Paul Cann
Principal Drainage Engineer
Engineering Services

APPLICATION NO: BN/23/20/DOC

Site Address: Coniston Lake Lane Barnham PO22 0AD

Description of Works: Approval of details reserved by condition imposed under ref BN/23/15/PL relating to Condition No 5 - surface water drainage, 6 - discharge of any flows to watercourses and 7 - future access & Maintenance of any watercourse or culvert

Record of As Bolt Construction

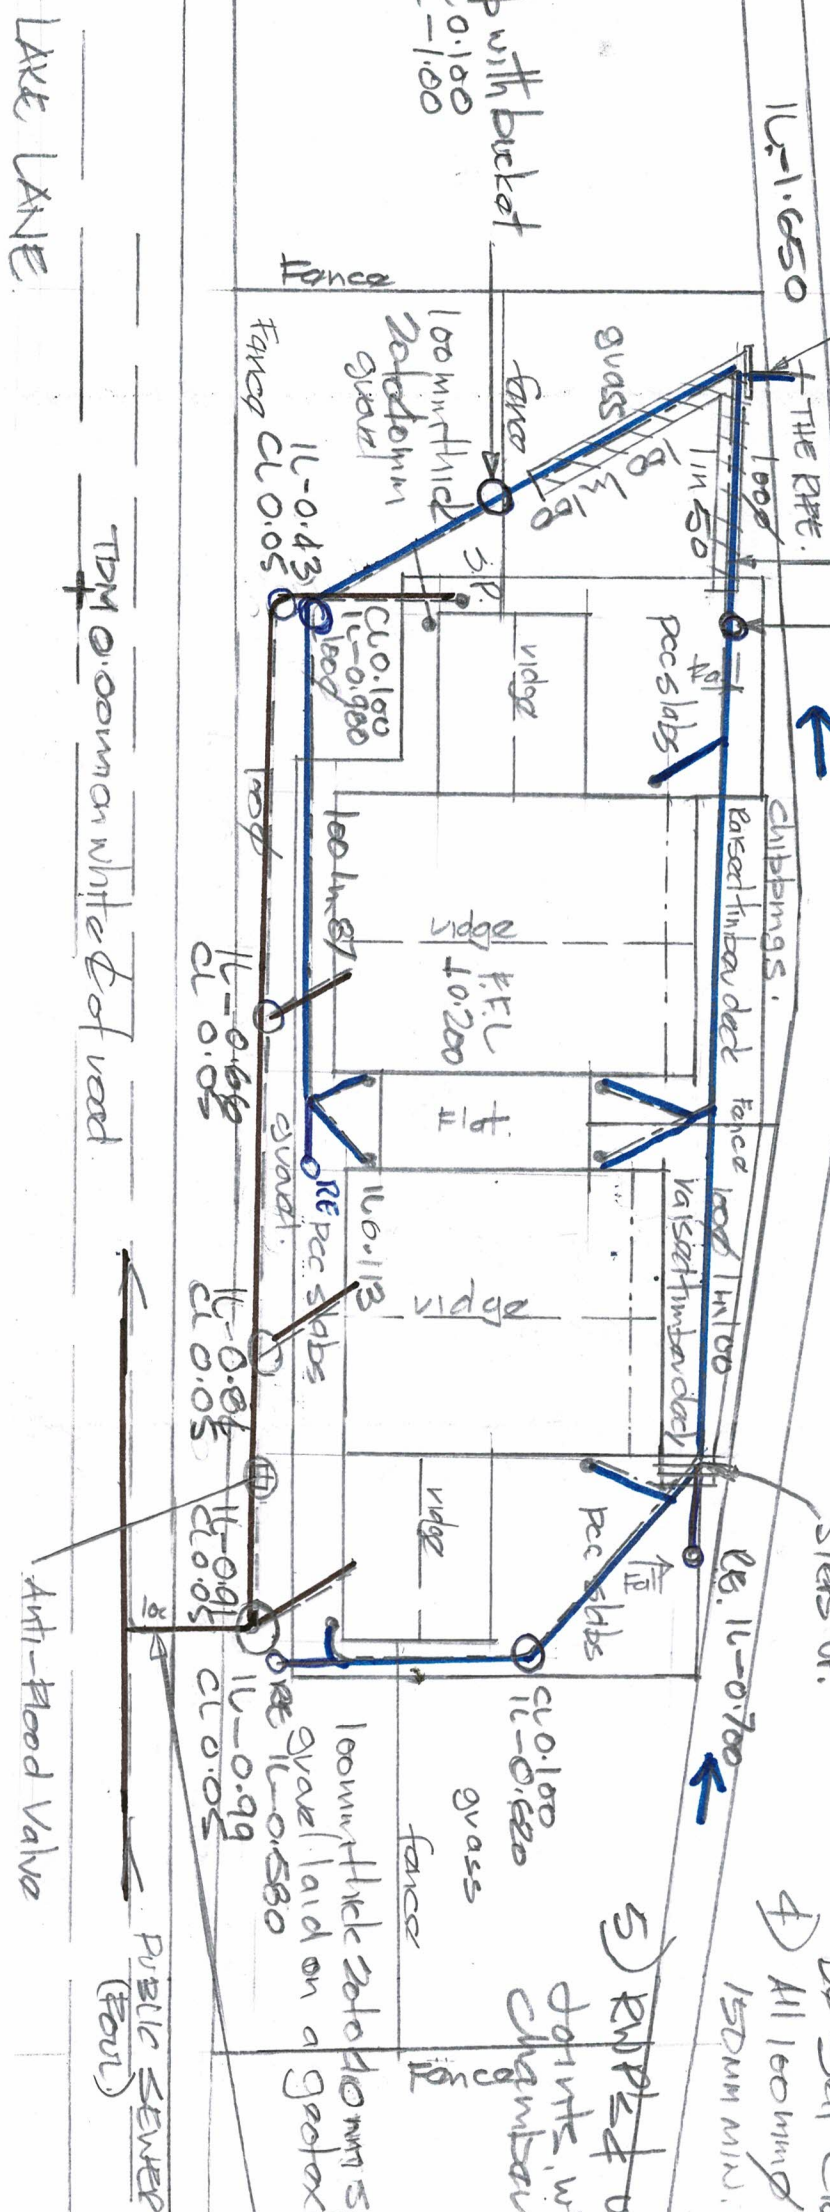
1. Ok
2. Numerous invert levels have been changed. The invert level of the silt trap manhole is not clear (-0.900?), neither is the rodding eye invert level. Please provide clarity on the drawing.
3. Revised drawing 535/02 has not been received.

Please note that since the development has already been constructed, it will need to be proven that what exists on site, reflects what is shown the drawings once finally approved.

1. RWP connection on east side of building is shown connecting against the flow in the carrier drain. Please clarify what was built and alter drawing accordingly.
2. Rodding eye east side of building (invert level 0.113). Is this the correct level?
3. Revised drawing 535/02 is required in order to address item 2 of my email dated 13.1.20.

Once the details are approved, an inspection to site will be required to check that what has been built corresponds to the approved drawings.
